From
 The Member Secretary,
 Madras Metropolitan
 Development Authority,
 Thalamuthu-Natarajan Building,
 No.8, Gandhi Irwin Road,
 MADRAS: 600 008

Lr.No.D.Dis. A/5938/89. dated: -2-90.

Sub: MMDA - Planning permission - Construction
 of Residential building in Plot No. Ponnankinaru street
 at S.No. 12/1, Block No. 2 of Malligaichery village.
 village - Approval - Regarding.

PLAN SHOWING THE PROPOSED DWELLING HOUSE AT T.S. NO:12/1, BLOCK NO: 2. 73/A MALIKASSERY VILLAGE, PONNANKINARU STREET, VILLIVAKKAM, MADRAS - 49.

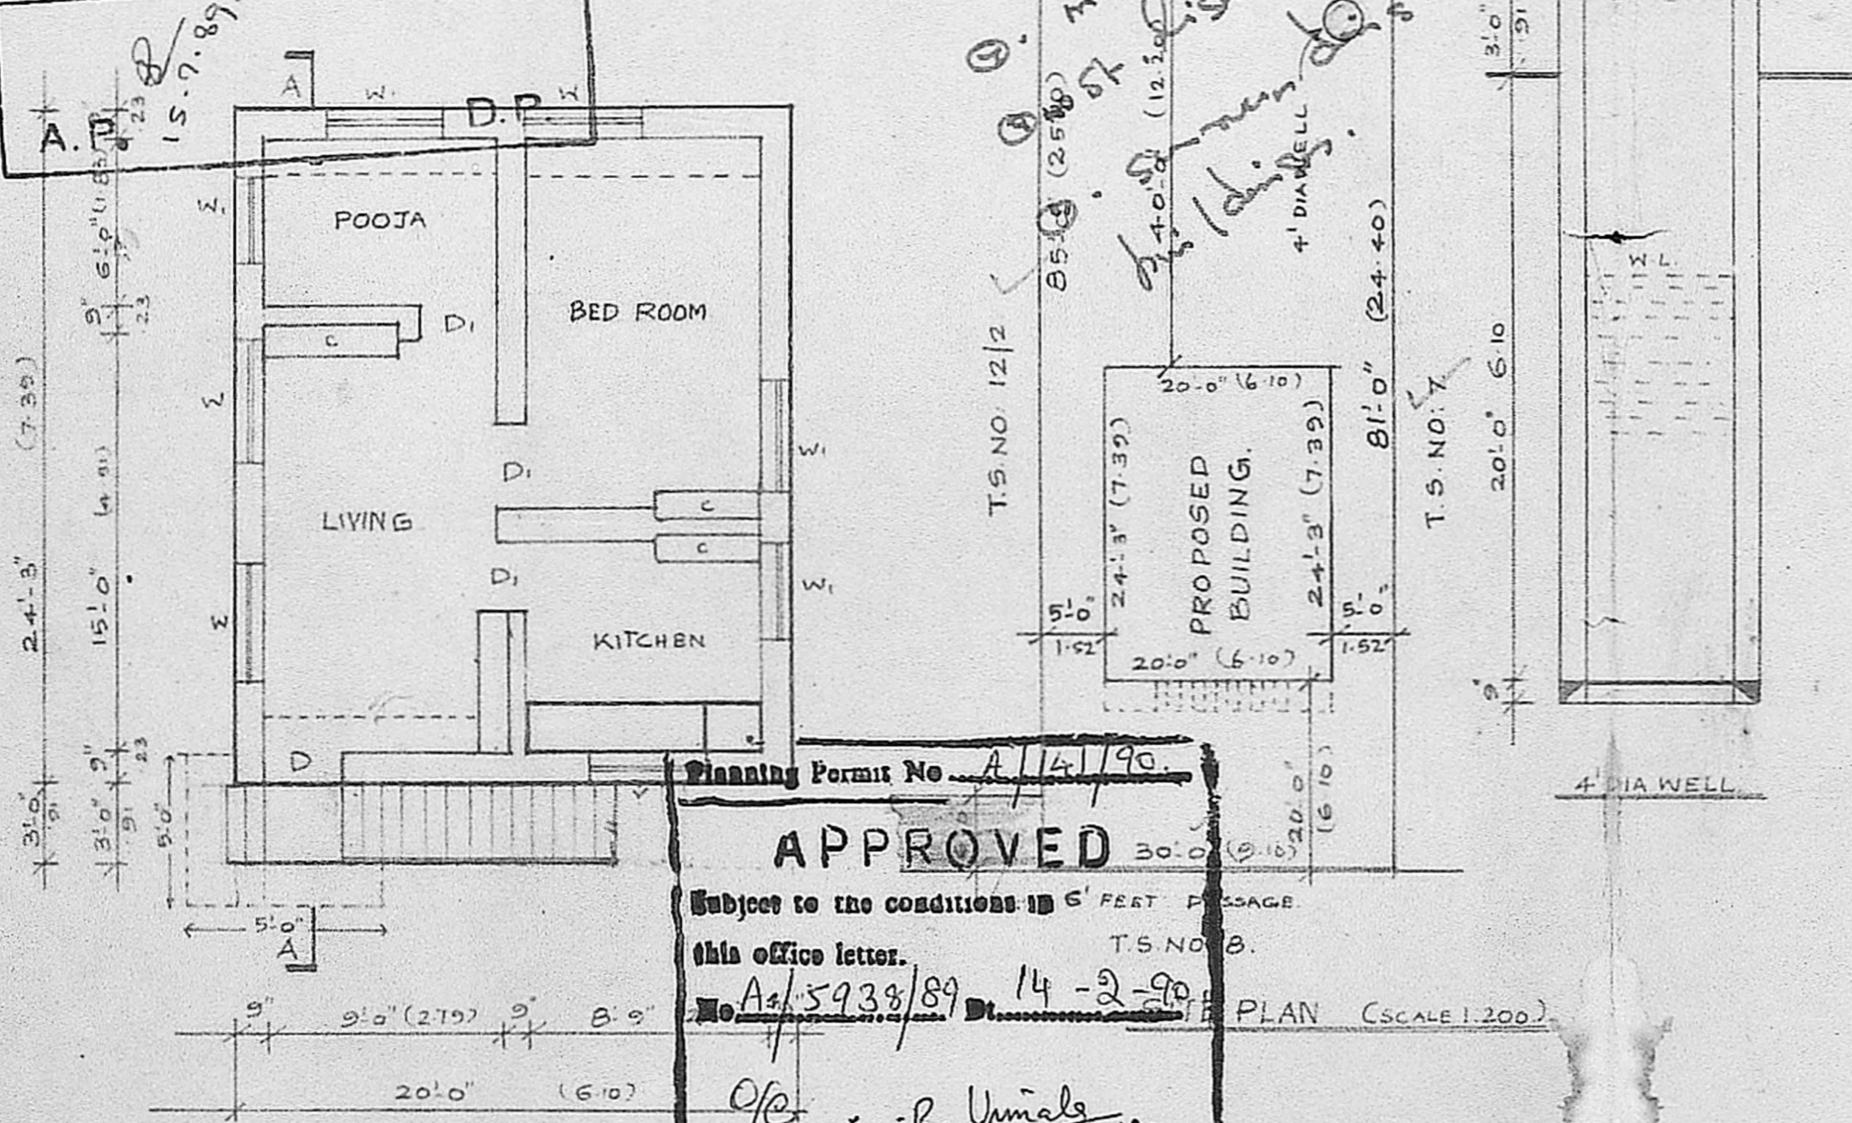
o Reliving passage
 and repairs
 width requirement.
 the unauthorised
 sub-division and
